Developer Services
Southern Water
Sparrowgrove House
Sparrowgrove
Otterbourne
Hampshire
SO21 2SW

A/17/17/HH

Proposal: Single storey rear extension & relocation of timber fence.

Site: 9 Bramley Way, Angmering, BN16 4GA.

Block Plan

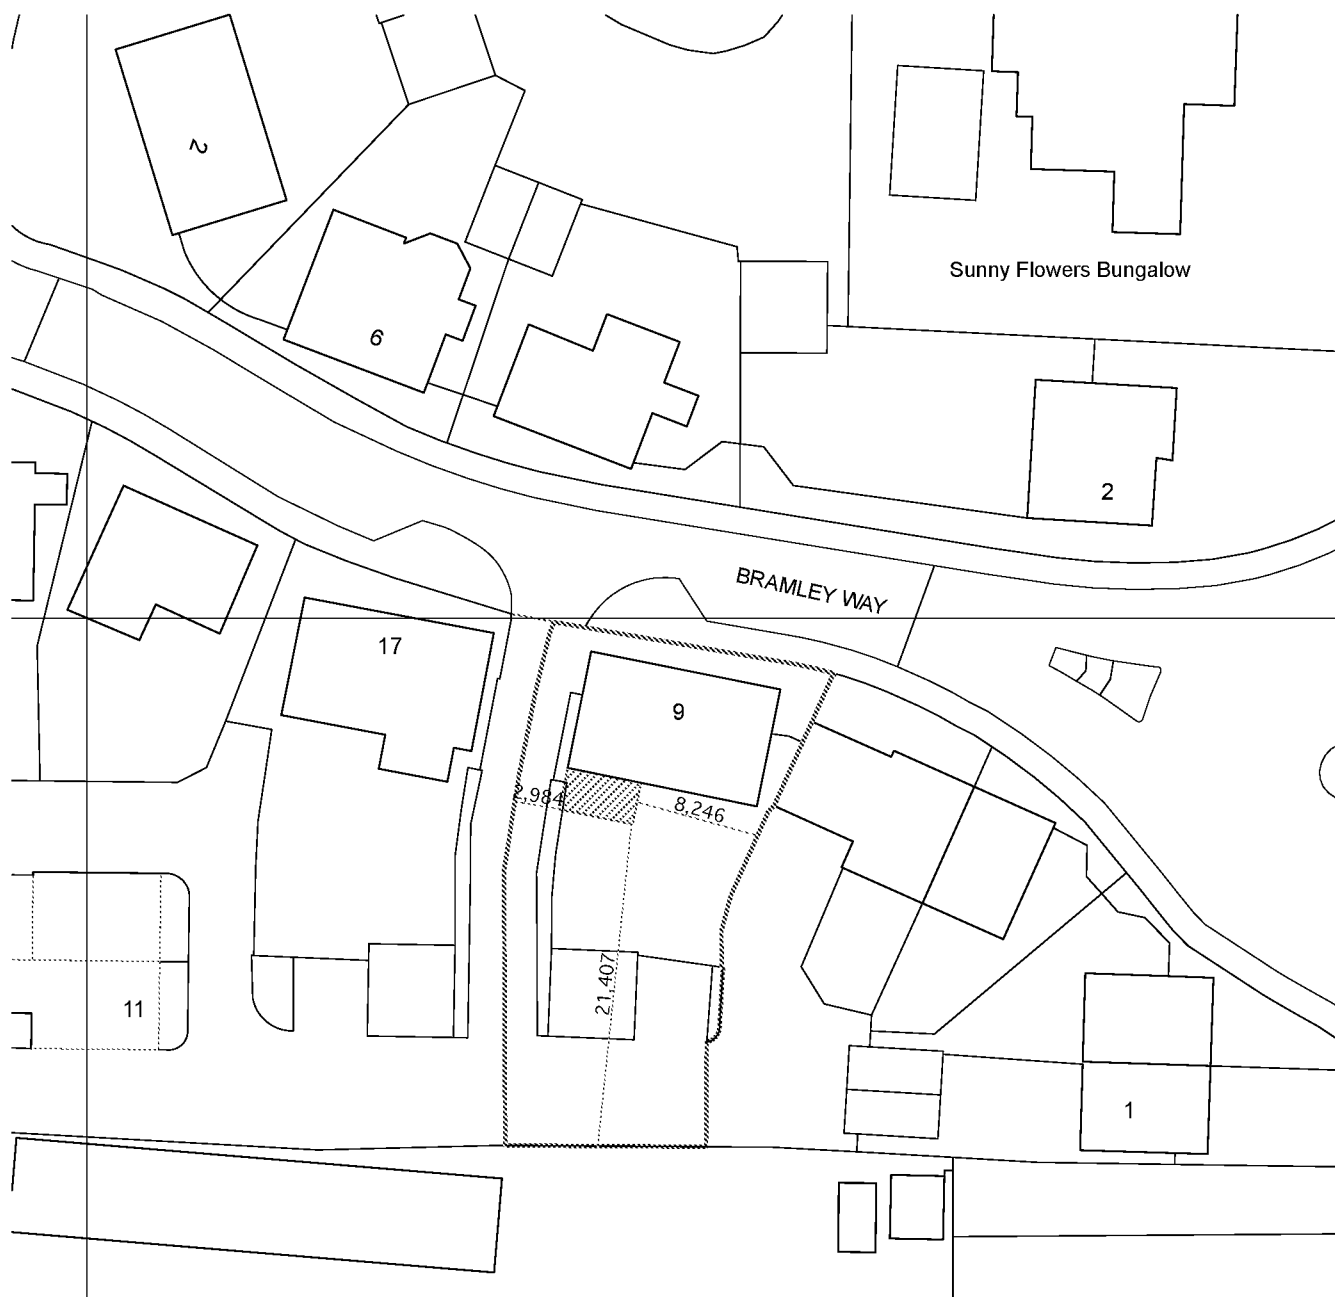
It appears that the developer is intending to build over a public foul sewer which is crossing the site. Building over a "public sewer" is not normally permitted by Southern Water.

However, under certain circumstances building over a sewer may be allowed. The conditions associated with the buildover/close to a sewer are contained in Southern Water guidance notes which are available at: www.southernwater.co.uk. A formal application to build close to the sewer will required to be submitted by the applicant
